Planning Application No

3/2021/1004

From: [REDACTED]
Sent: 14 November 2021 23:15
To: Planning
Subject: Planning Application No:3/2021/1004

Address of Development: 1 - 7 George Street Whalley BB7 9TH

Proposed Elevations

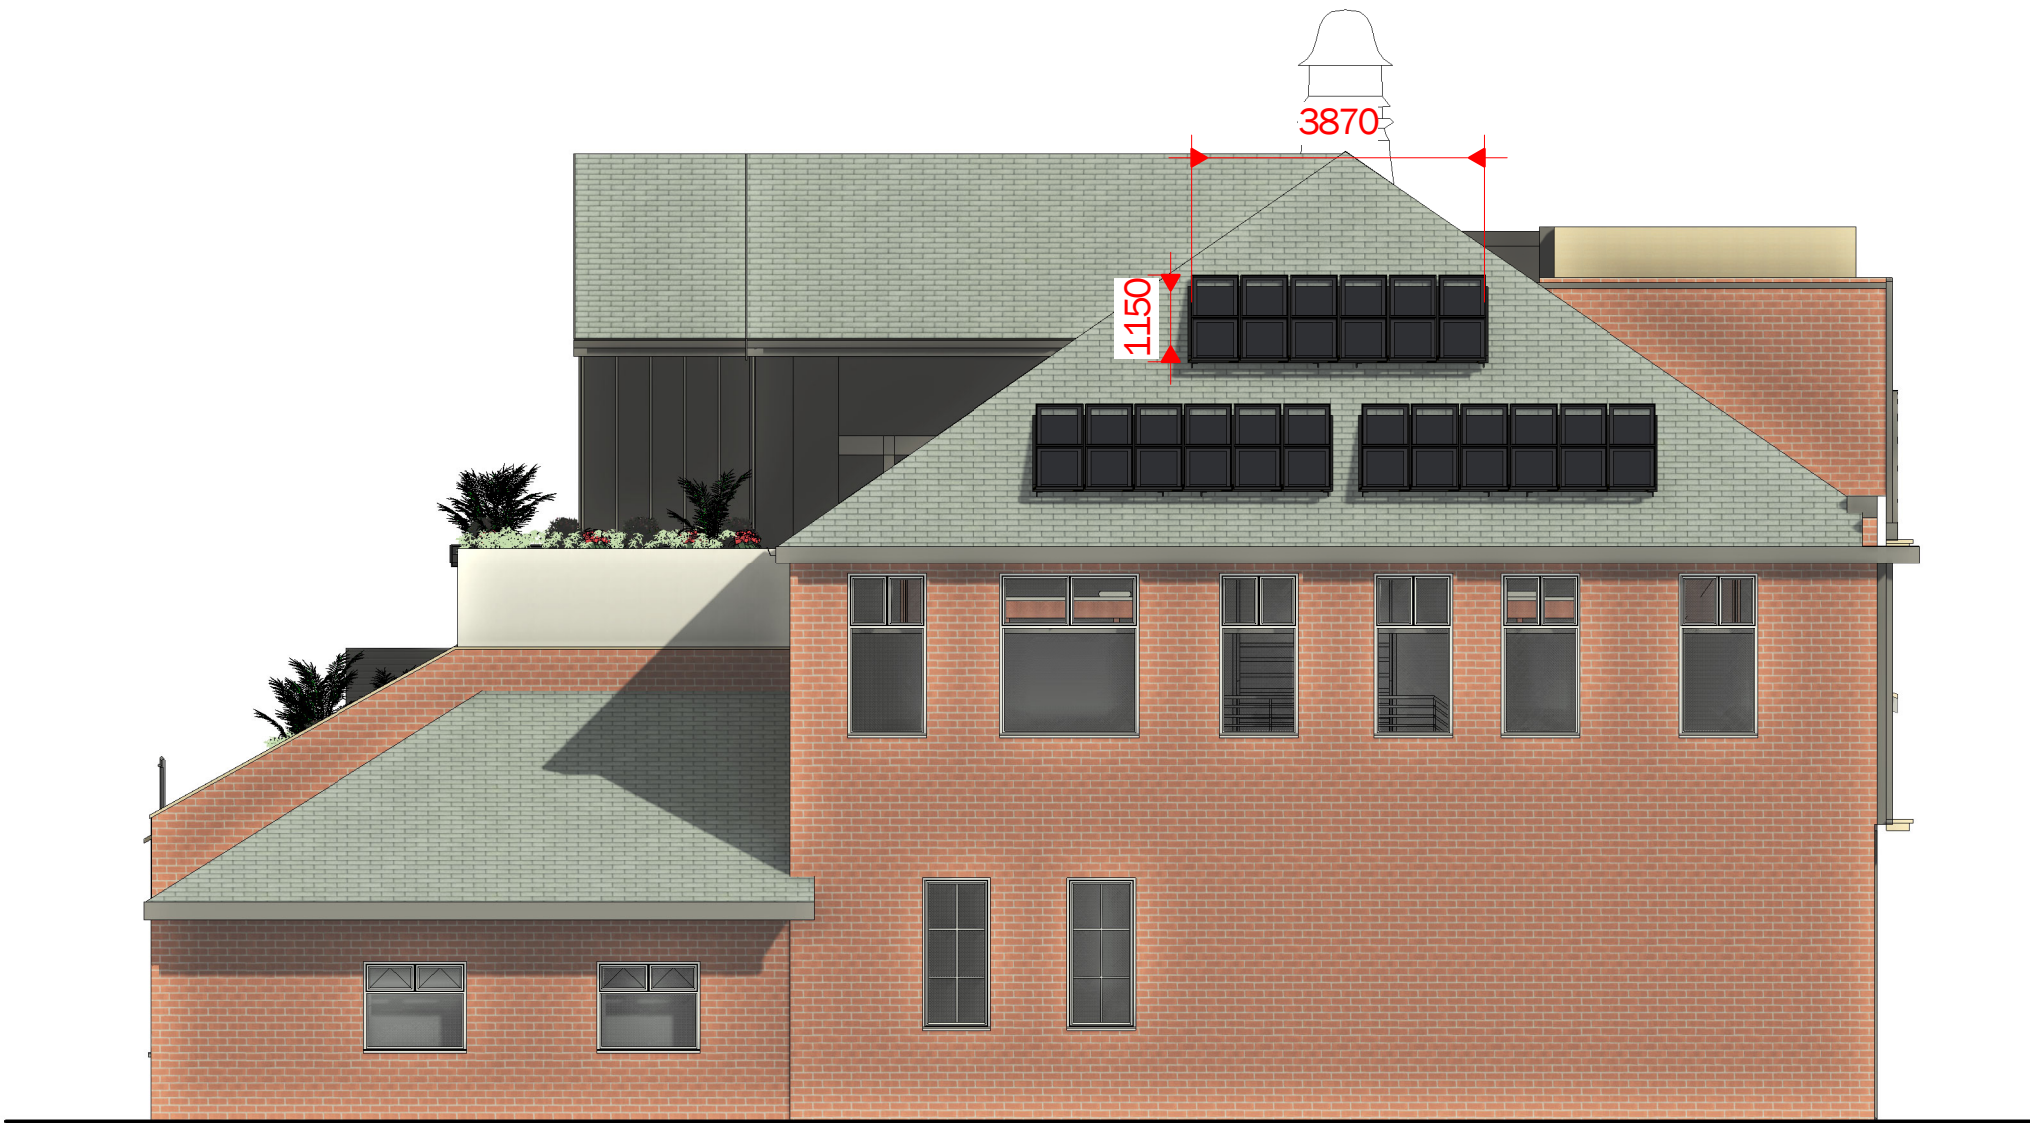
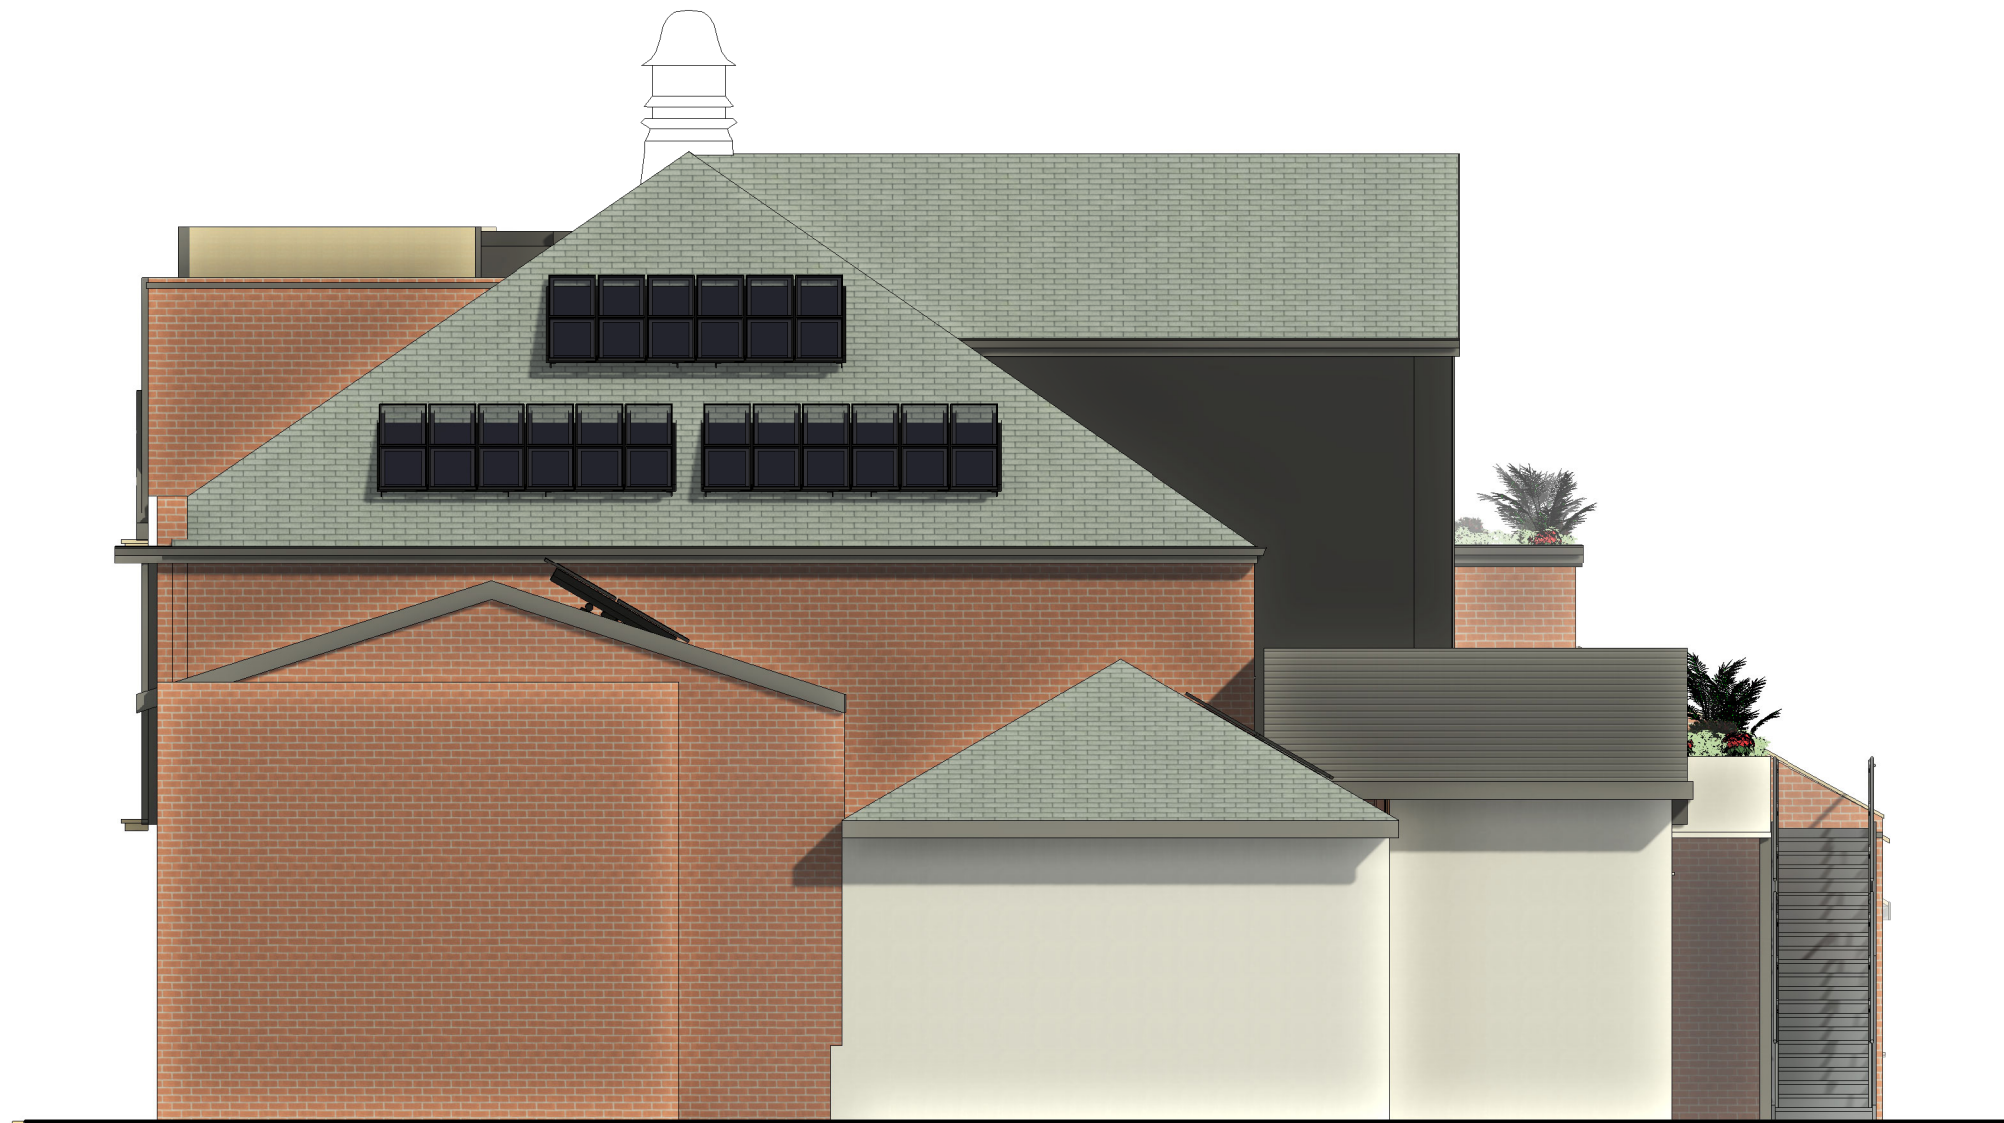
There has never been a requirement for pedestrian or vehicle access to the rear of the commercial properties of 1 to 7 George Street other than to the loading bay adjacent to the rear of 12 Church Lane whether at day or night. The new access to the proposed apartments as well as the feature balconies will now require a high level of illumination which will be sited within around 12 metres from the rear walls and windows of the residential properties on Church Lane and maybe 3 or 4 metres from their boundary walls. It will therefore be essential to shade this lighting so as to comply strictly with current residential and street lighting regulations.

It is to the credit of the owners that, according to the plans, there are a number of solar panels located so as to take advantage of the entirely exposed south facing aspect of the roof and upper floors. It is hoped that this feature is locked in as a requirement of planning consent (even if this constitutes a 'first' in such approval) and it should be noted that further roof areas are available should the entire building require it.

Proposed Ground &
First Floor Plans

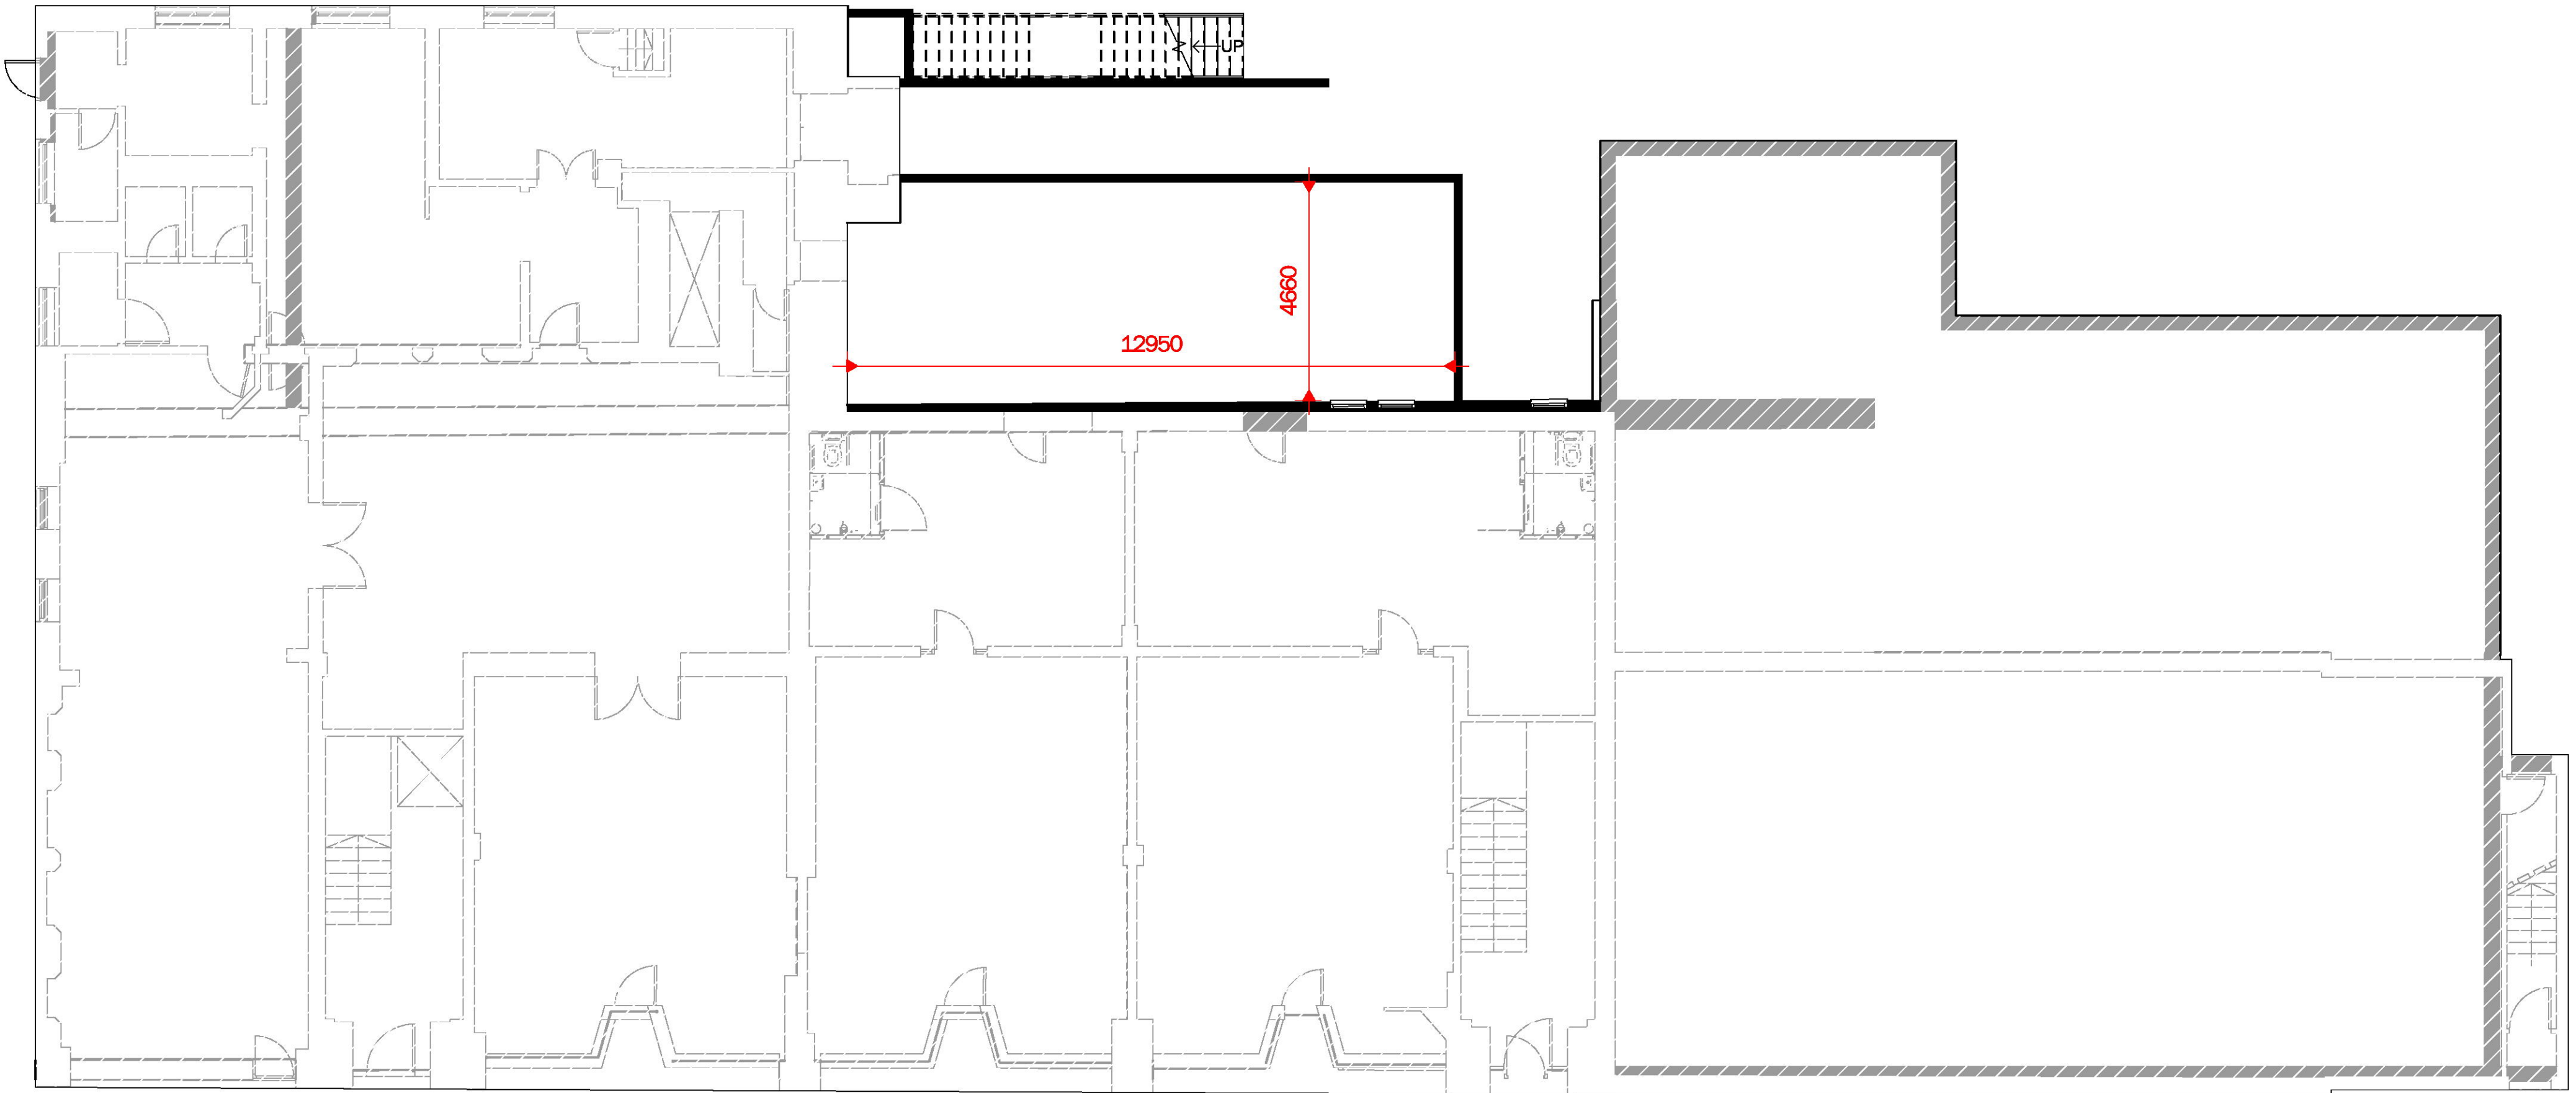
The planning also indicates that the loading bay at the rear of 1-7 George Street is to be demolished and alterations made to the rear of the building. This raises concern as to how deliveries are to be made to the businesses on George Street.
